**Consultation Response from KC,
Highways Development Management**

2024/92910 Land Adjacent, 45, Coal Pit Lane, Lower Cumberworth, Huddersfield, HD8 8PL

Demolition of dwelling and barn and erection of two dwellings with associated external alterations

Date Responded: 11-3-2025.

Proposed site plan (1:200)

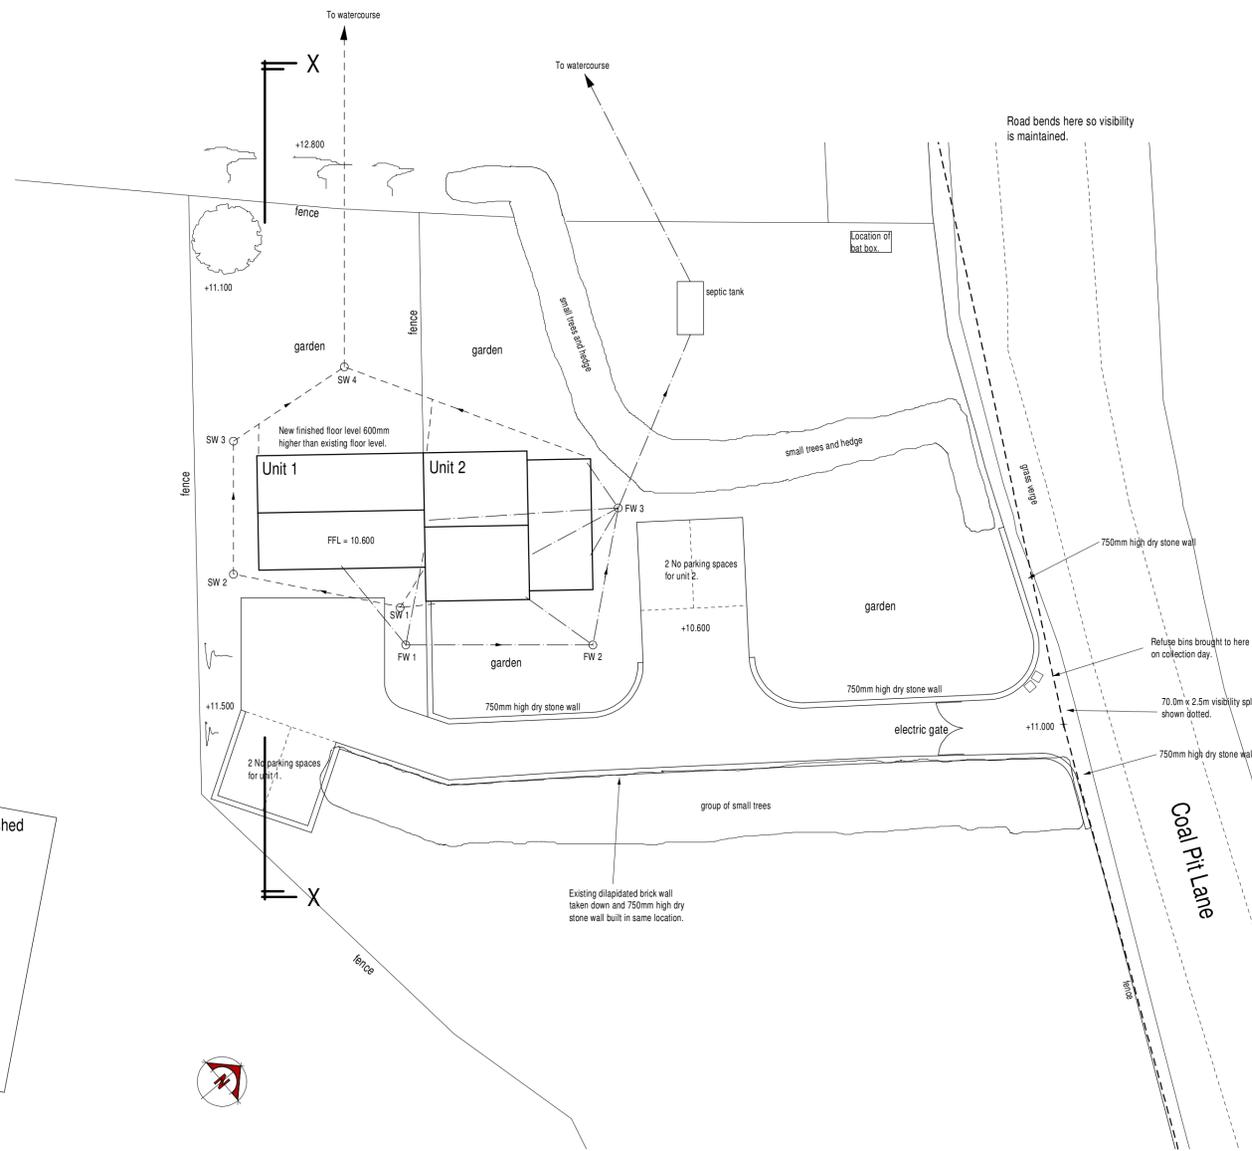
The proposals show 2 new 3 bedroomed dwellings on approximately the same footprint as the existing structures which are to be demolished. A new access is proposed onto Coal Pit Lane with electric gates set back from the highway. 2.4 x 70m sight lines are shown from the proposed access onto Coal Pit Lane in both directions.

Each of the 2 dwellings is shown to have 2 off-street parking spaces with space to allow internal vehicle turning and bin collection points are shown at the site access.

Given the previous permission Highways Development Management have no objection to these proposals.

Access Sightlines to be provided

Before development commences, the sightlines of 2.4m x 70m shall be cleared of all obstructions to visibility exceeding 1 m in height and these shall be retained free of any such obstruction.

Areas to be surfaced and drained

Prior to the development being brought into use, the approved vehicle parking areas shall be surfaced and drained in accordance with the Communities and Local Government; and Environment Agencies 'Guidance on the permeable surfacing of front gardens (**parking areas**)' published 13th May 2009 (ISBN 9781409804864) as amended or superseded; and thereafter retained throughout the lifetime of the development.
